## POST EPC MEMORANDUM

RE: PR-2022-007851, SI-2022-02075-Buddhist Temple, Site Plan – EPC Major Amendment

**Project # PR-2022-007851**

SI-2022-02075 - Site Plan- Major Amendment

5 SECTION @ TRASH
SCALE: 1/2" = 1'-0"

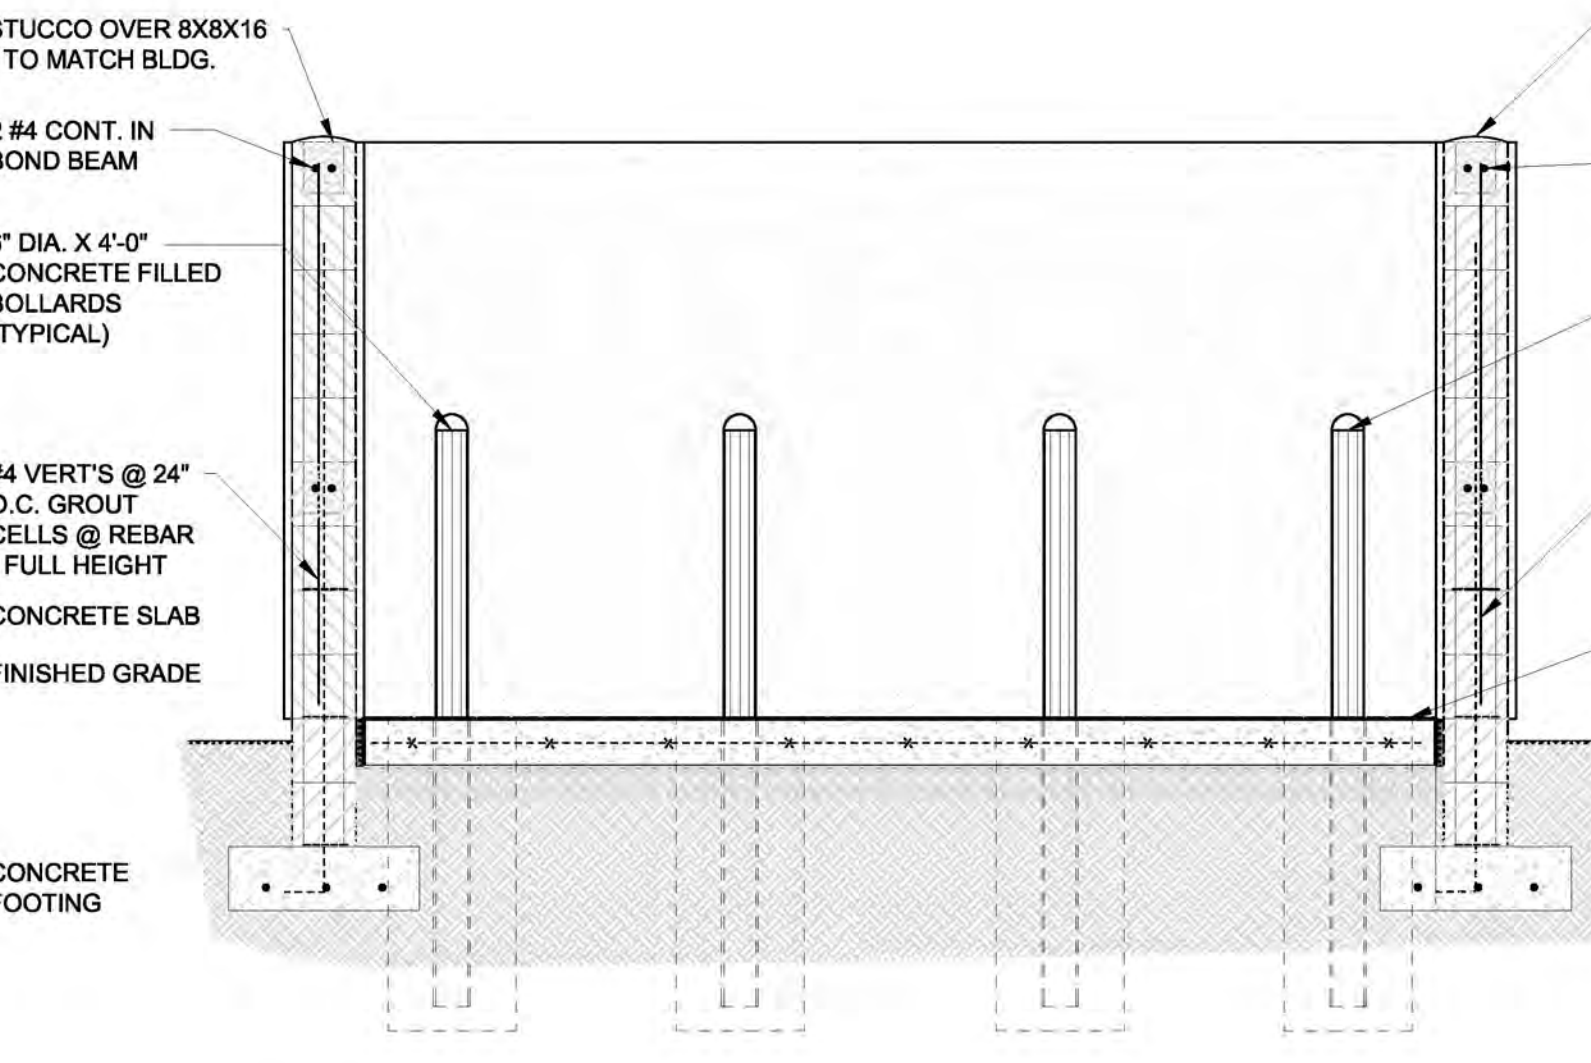
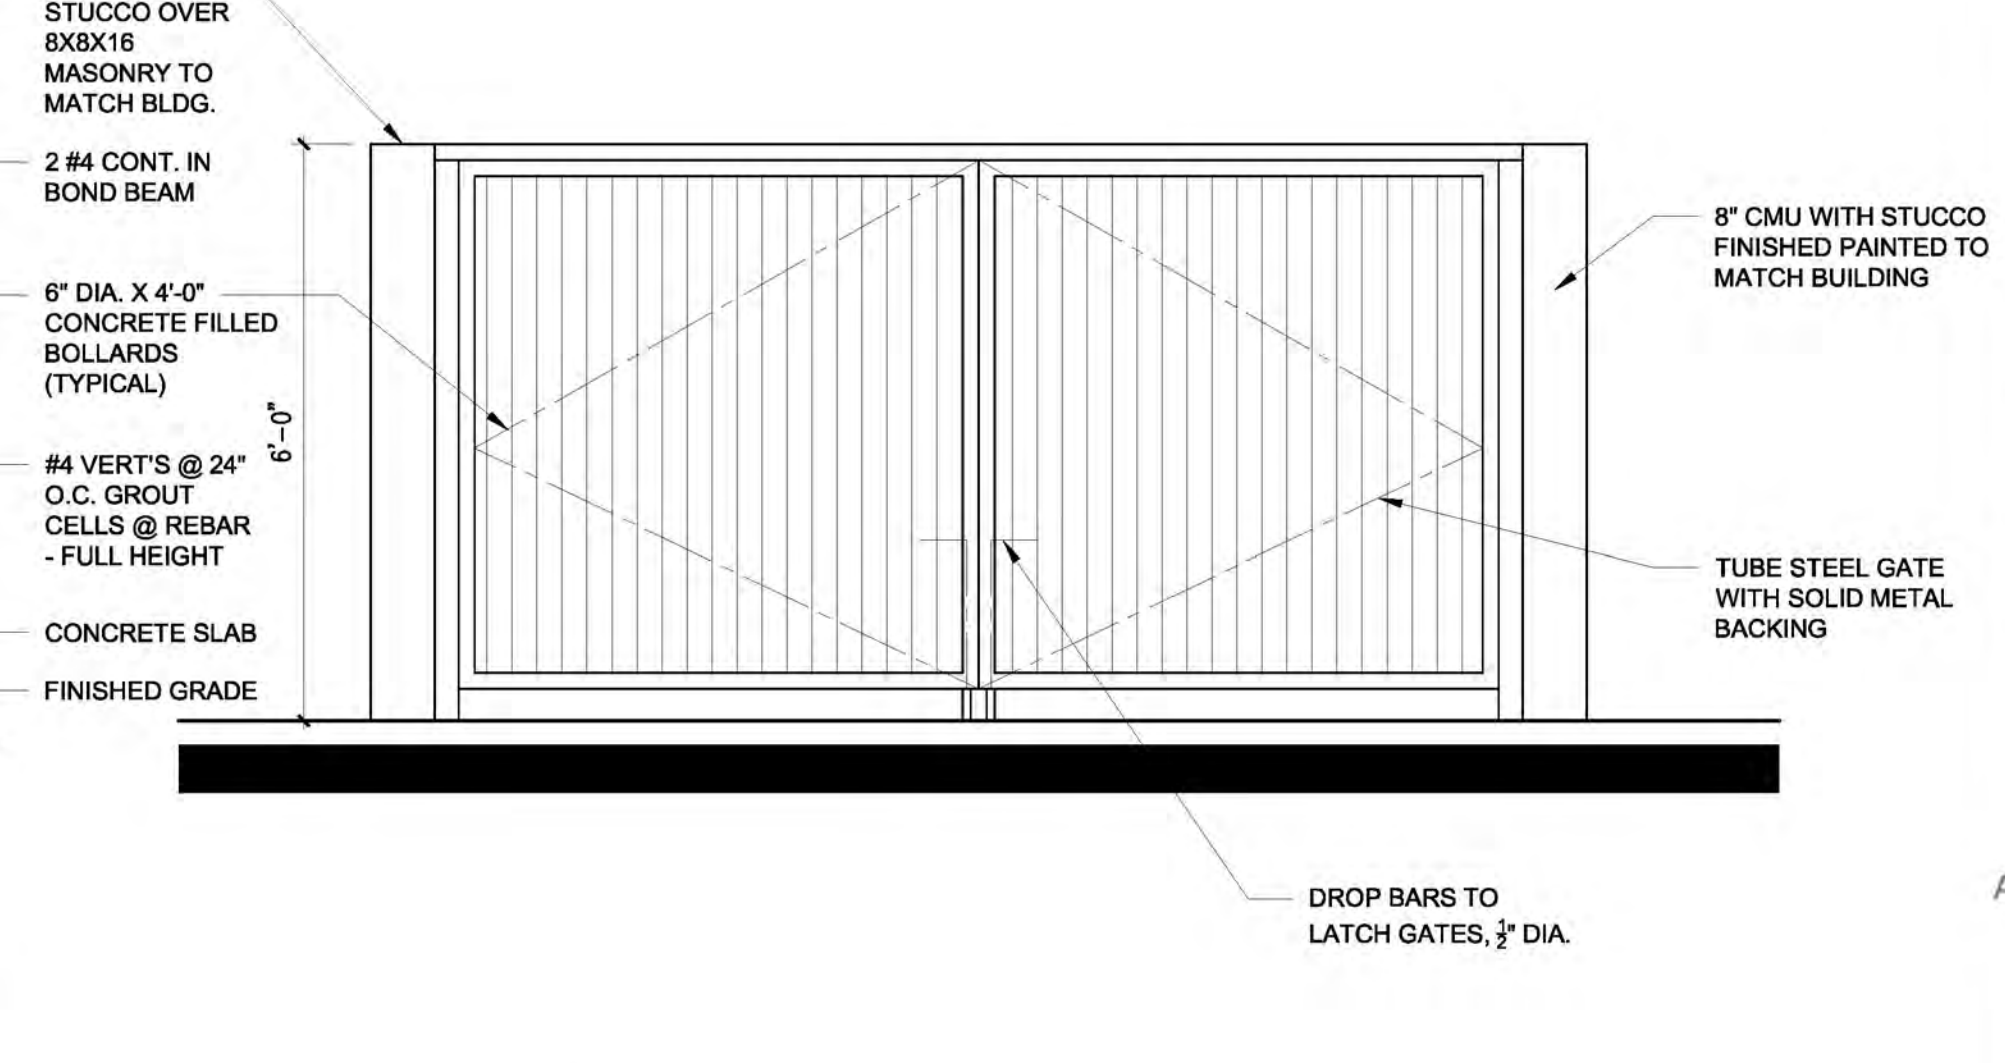
- B. The trash enclosure will have to meet the City of Albuquerque's minimum requirements.

The trash enclosure design on sheet A1.3 Plan & Details reflect the SWMD dimensions and construction materials requirements of the "enclosure specifications" document. This enclosure does not require an exterior sanitary sewer drain, this facility is not a "Restaurant, Food Services or Food Distributors" function.

A3.1
XX OF XX SHEET

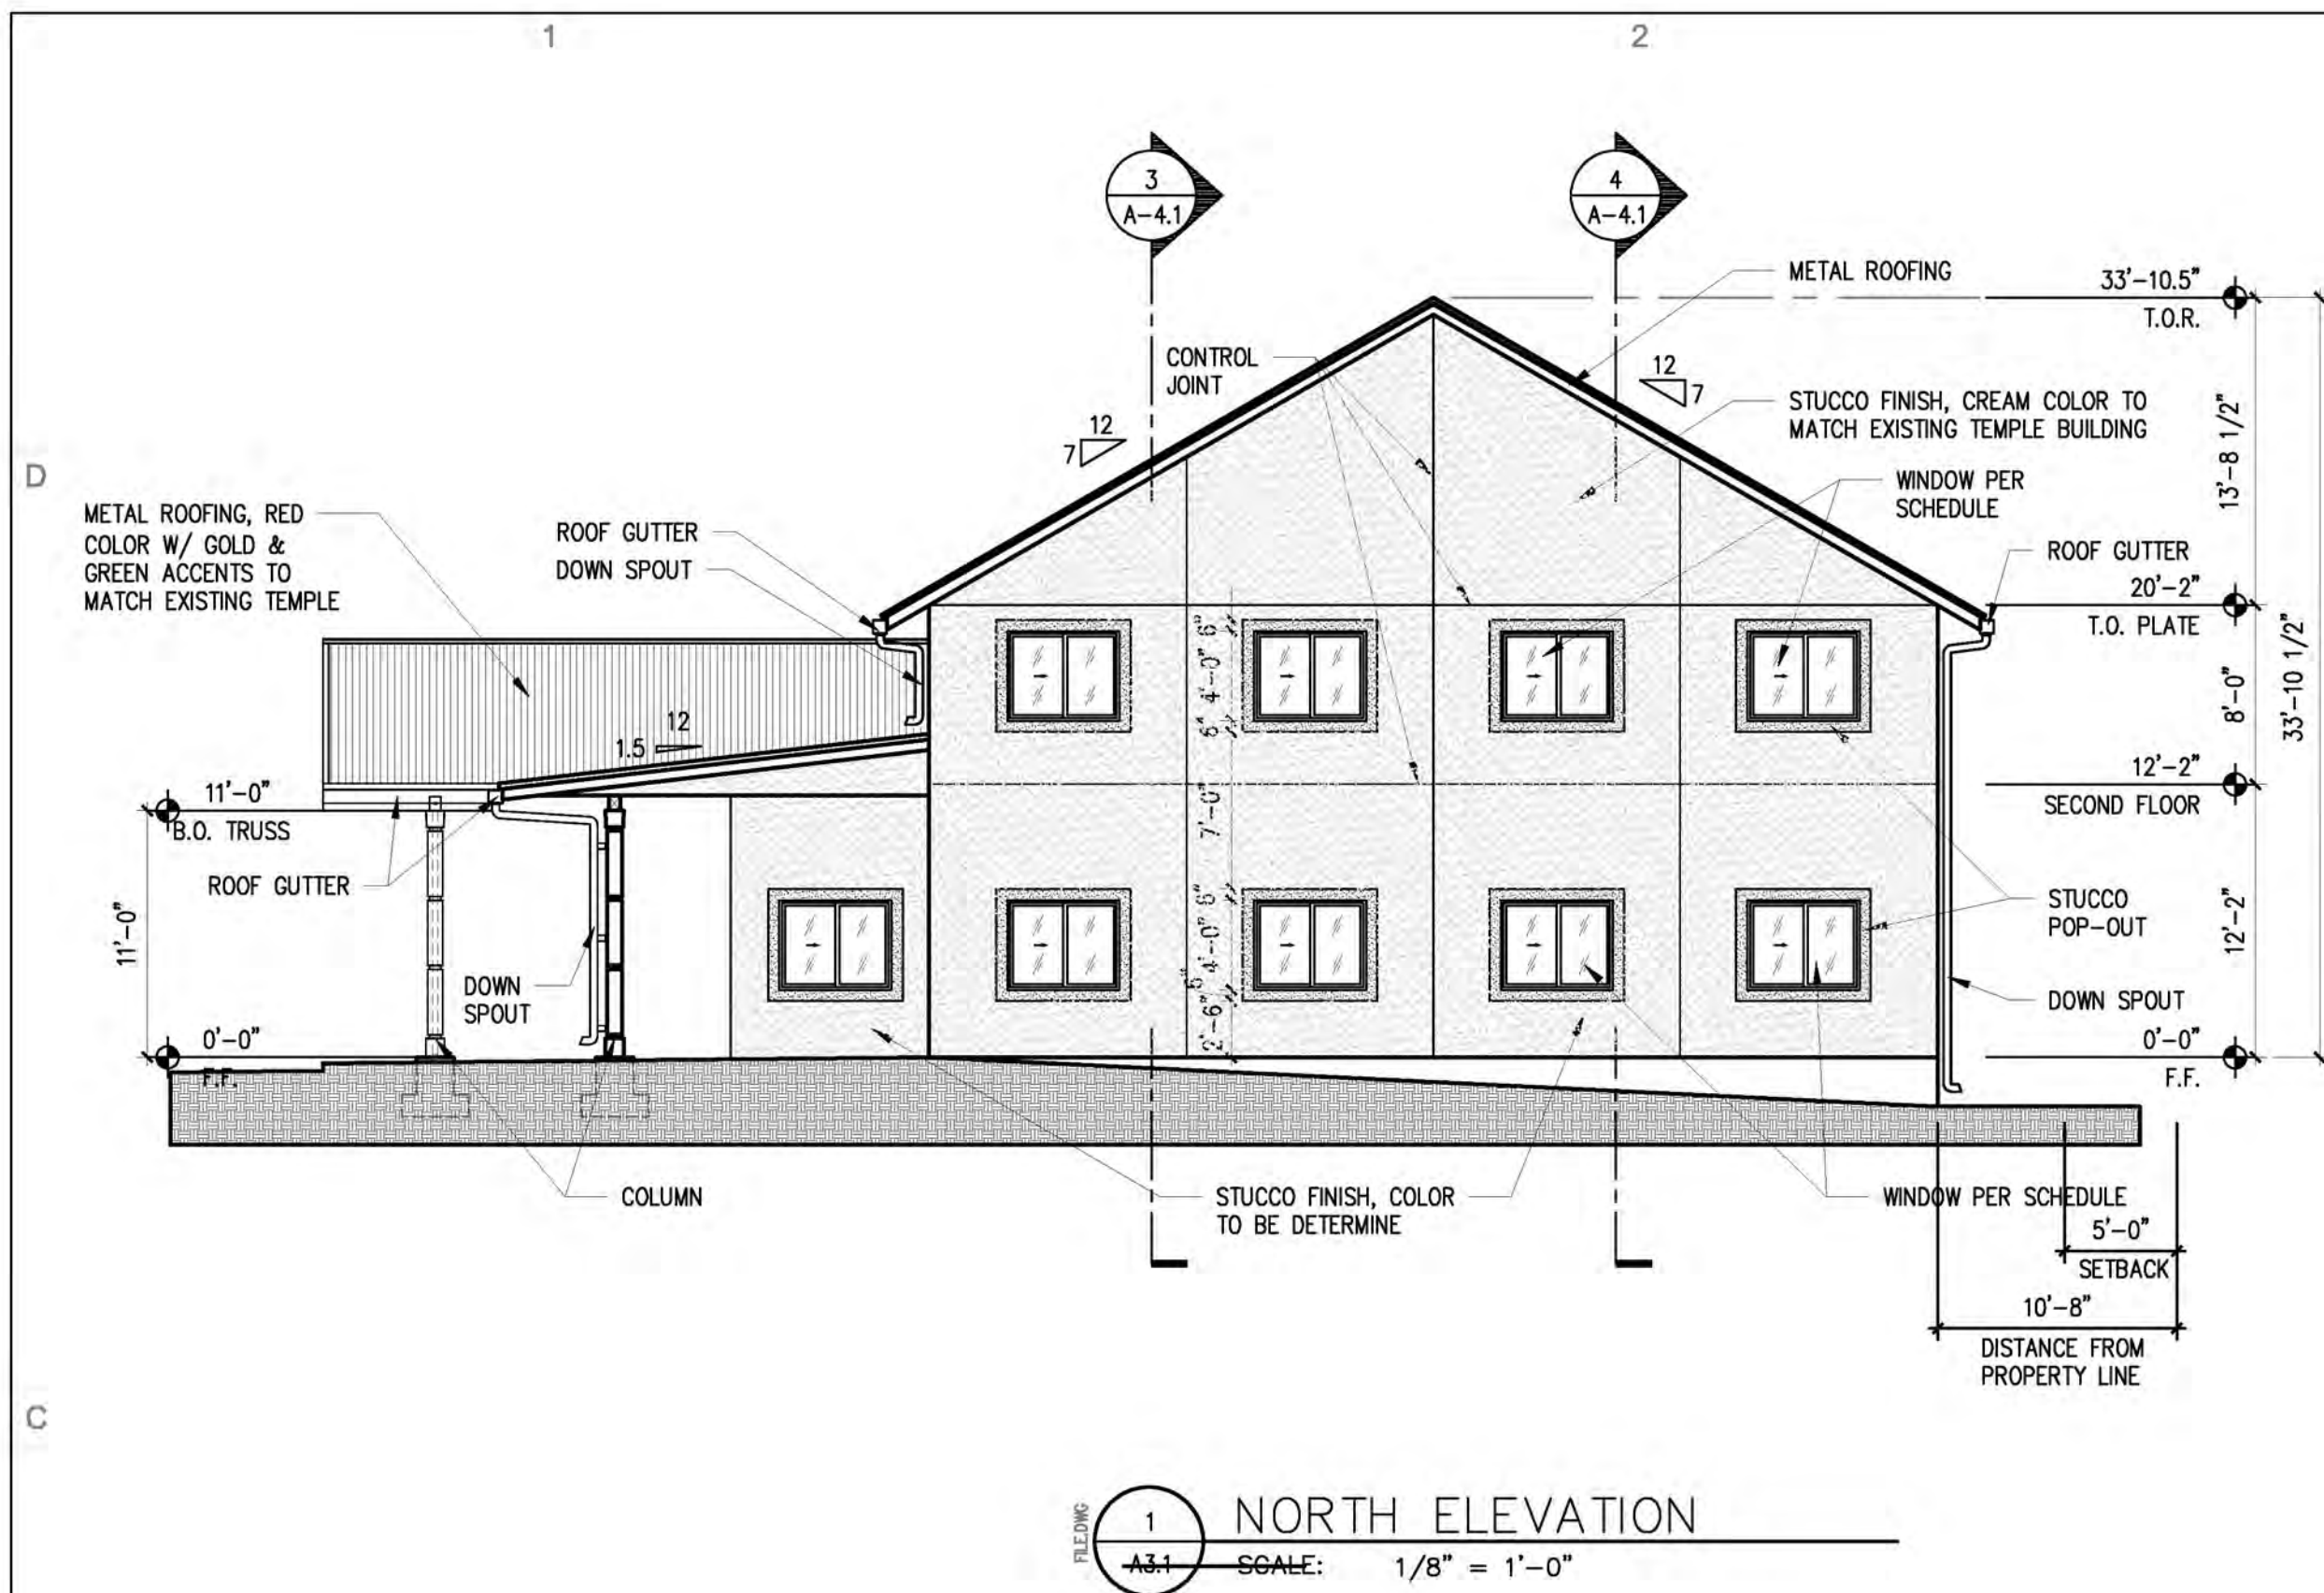
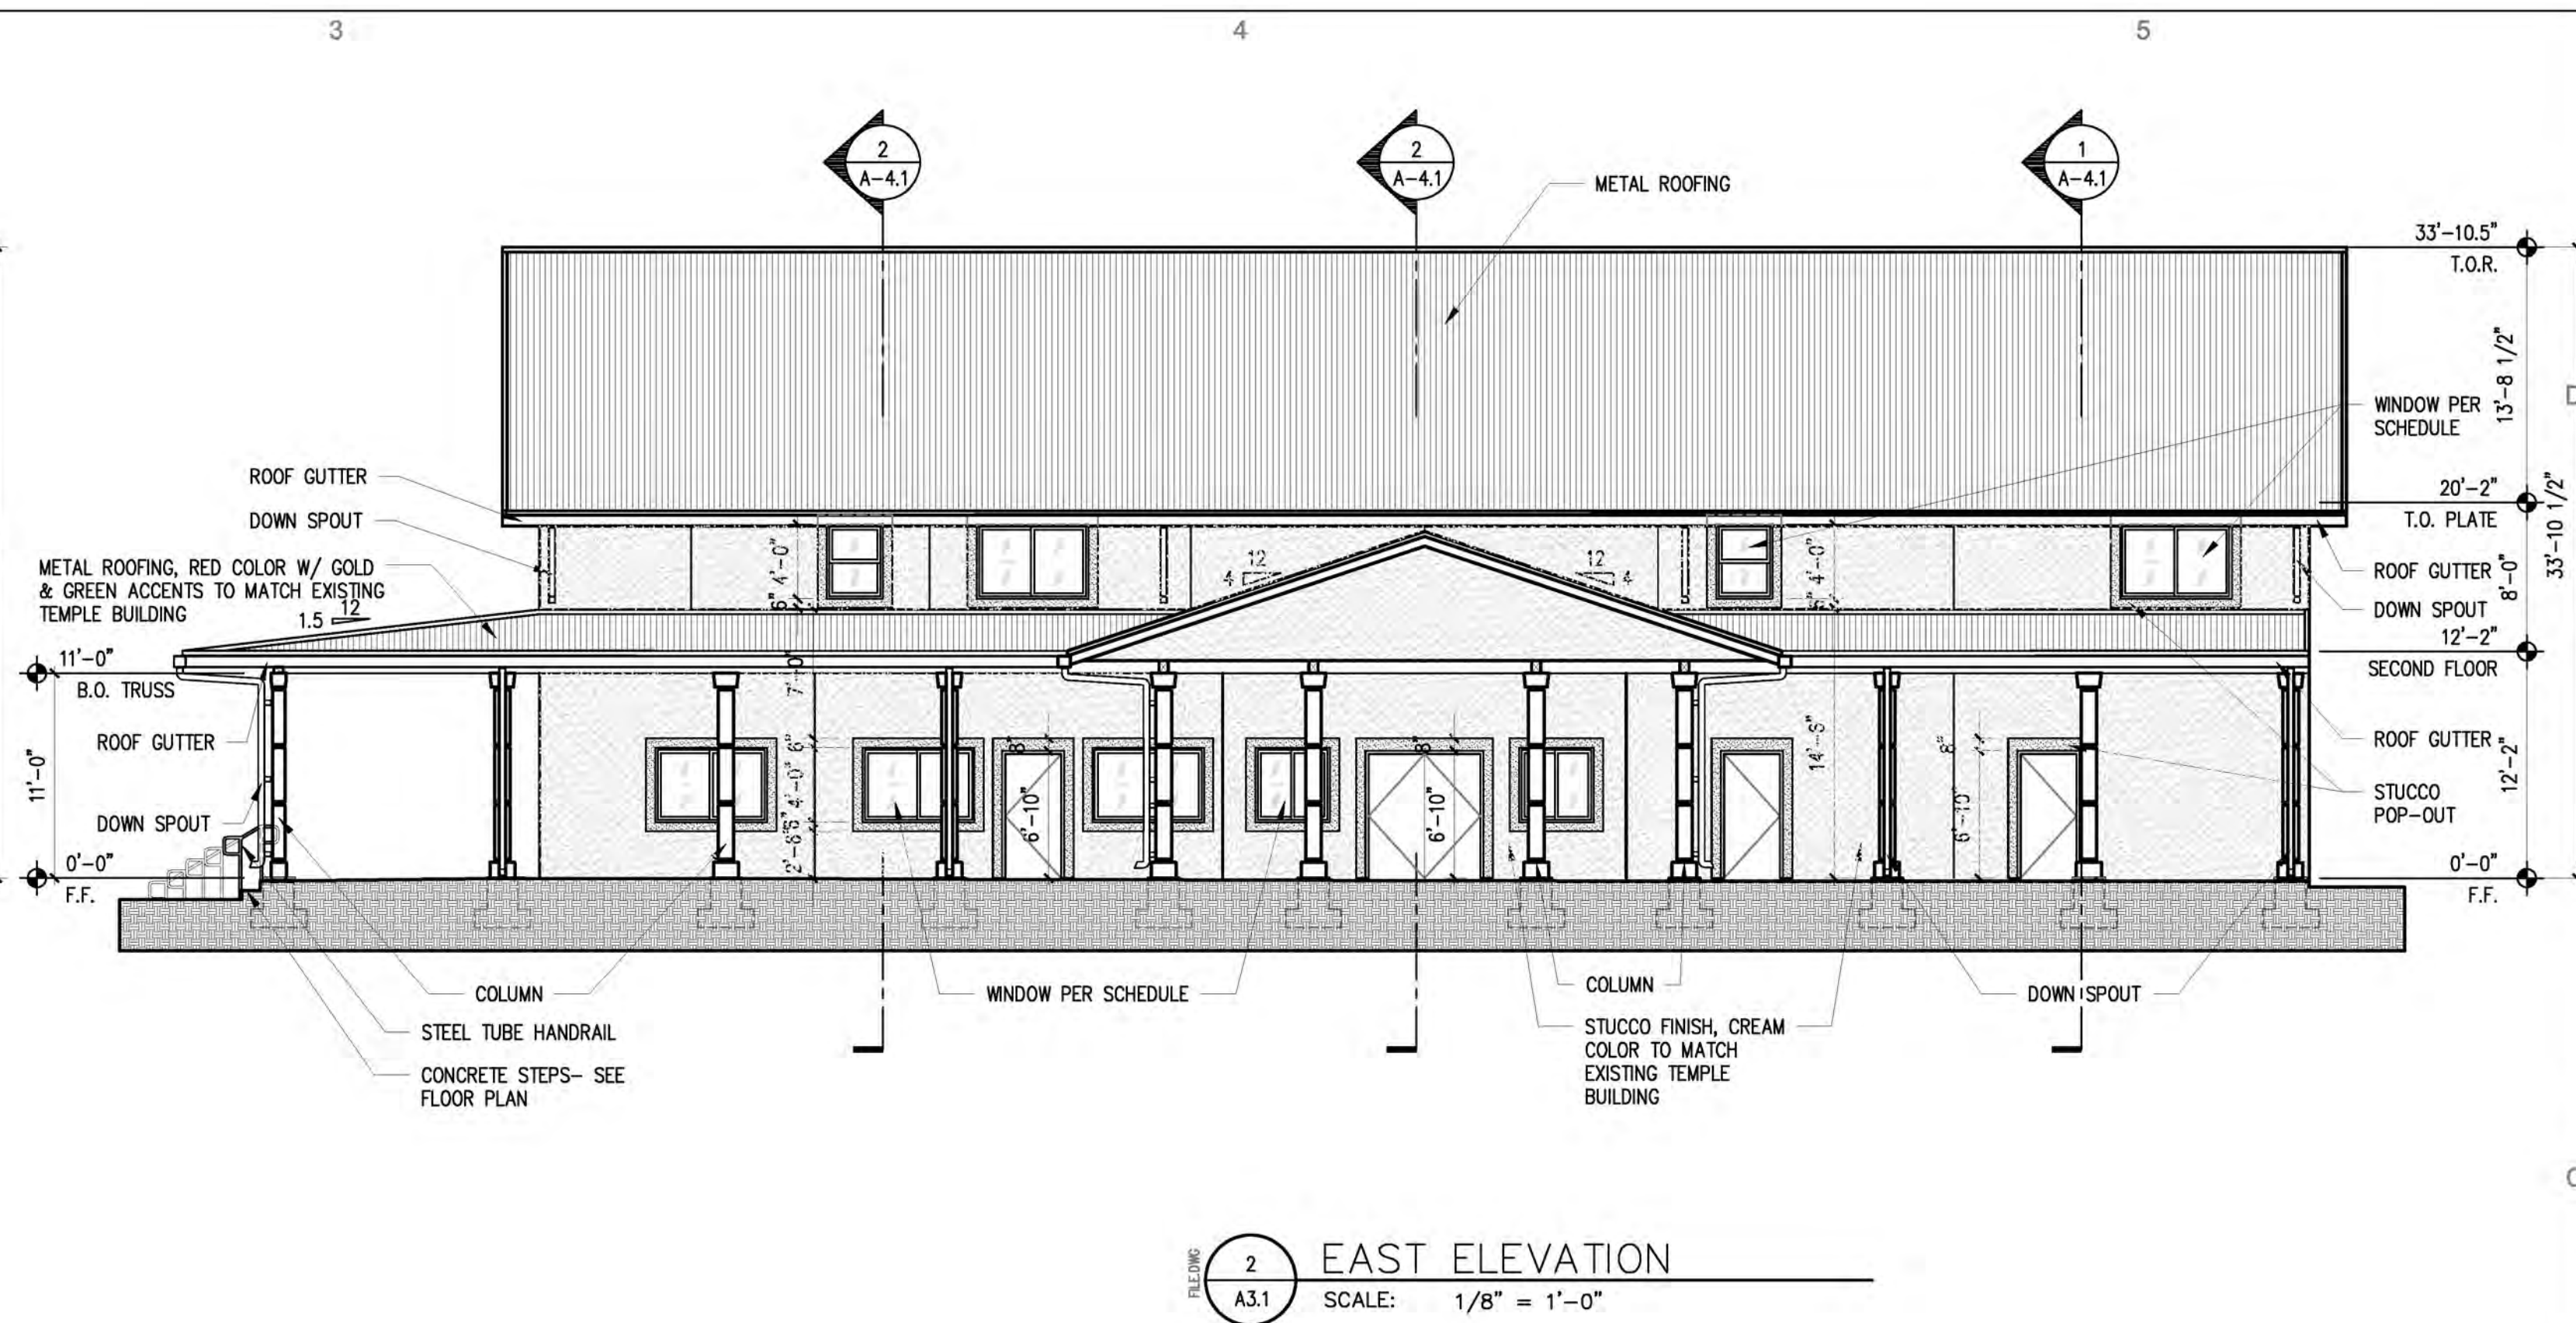
6. **Elevations** shall specify building materials and colors.

The building exterior stucco field colors will be similar to the exterior finishes of the existing Temple building. Cream color stucco for the exterior wall finish, gold color stucco "frames" around building window and door openings with red color accents. There will be a red metal roof panel with eave and soffit trim elements with gold and green color accents.
